Rezoning Transportation Analysis

Petition Number: 2022-121

From: Jake Carpenter, PE
Jacob.carpenter@charlottenc.gov
980-221-5675

Reviewer: Patrick Monroe
Patrick.Monroe@charlottenc.gov
704-301-1411

**RZ-5**

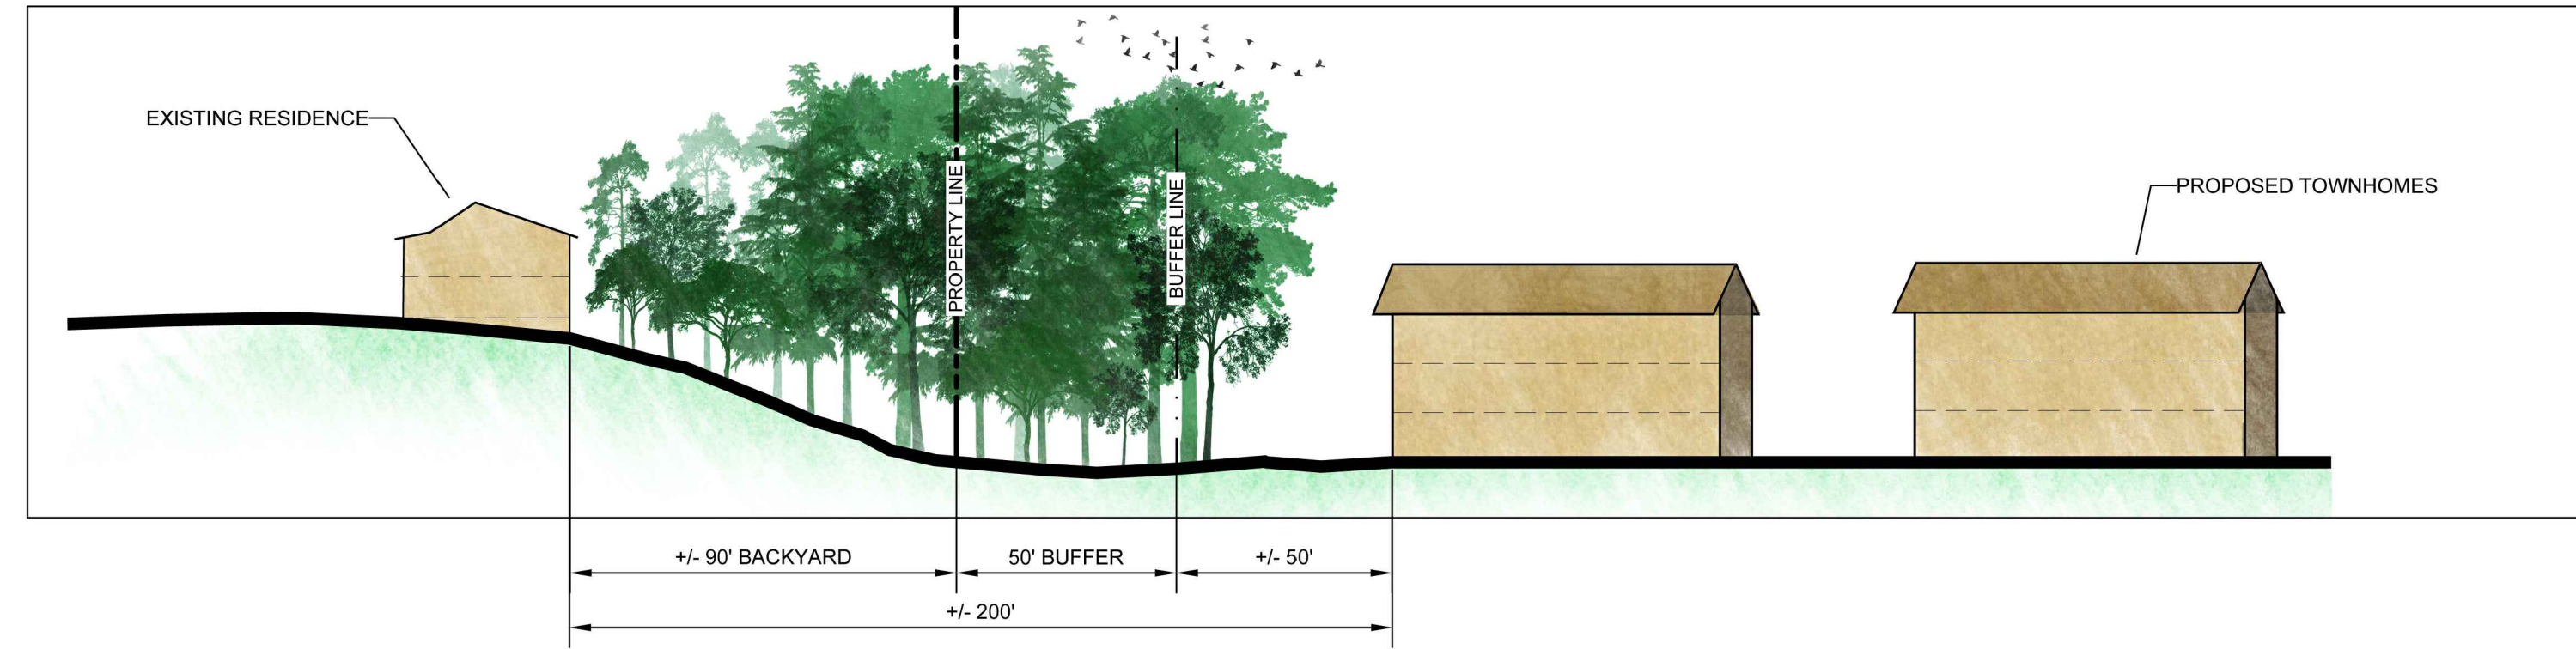
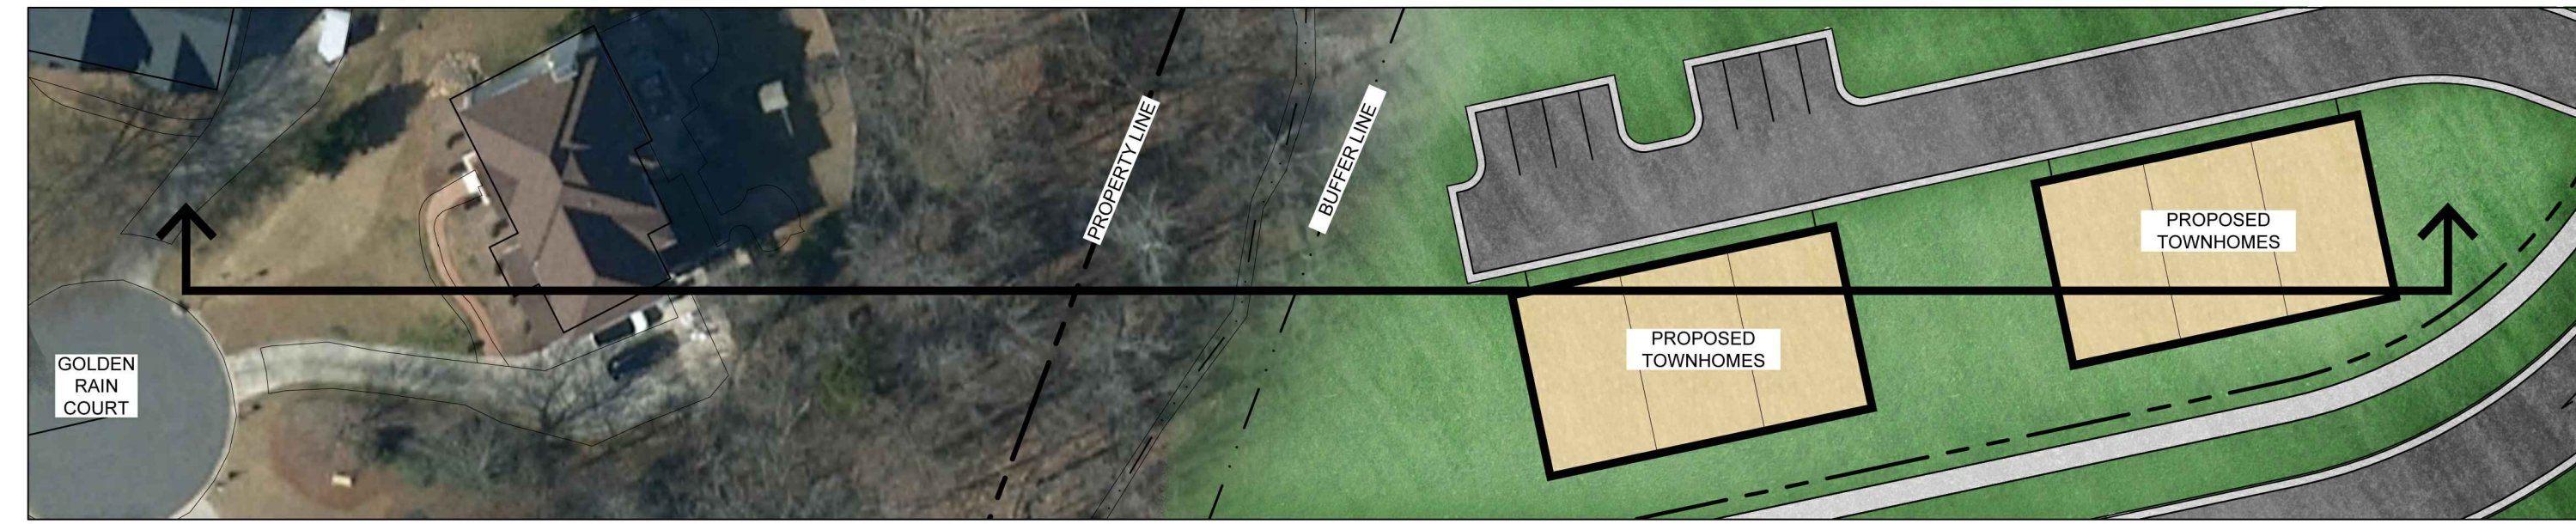
of Rea Road and Elm Lane that will go through the site connecting to the 4 Mile Creek Greenway via the 8' elevated pedestrian connection. Conditional note revisions needed regarding Elm Lane and Access B. Further details are listed below.

Update Comment from 8/23/2023: MUP needs to follow Rea Road for a greater distance. Engineering documentation needs to be provided to allow the required streetscape (MUP) to be constructed onsite.
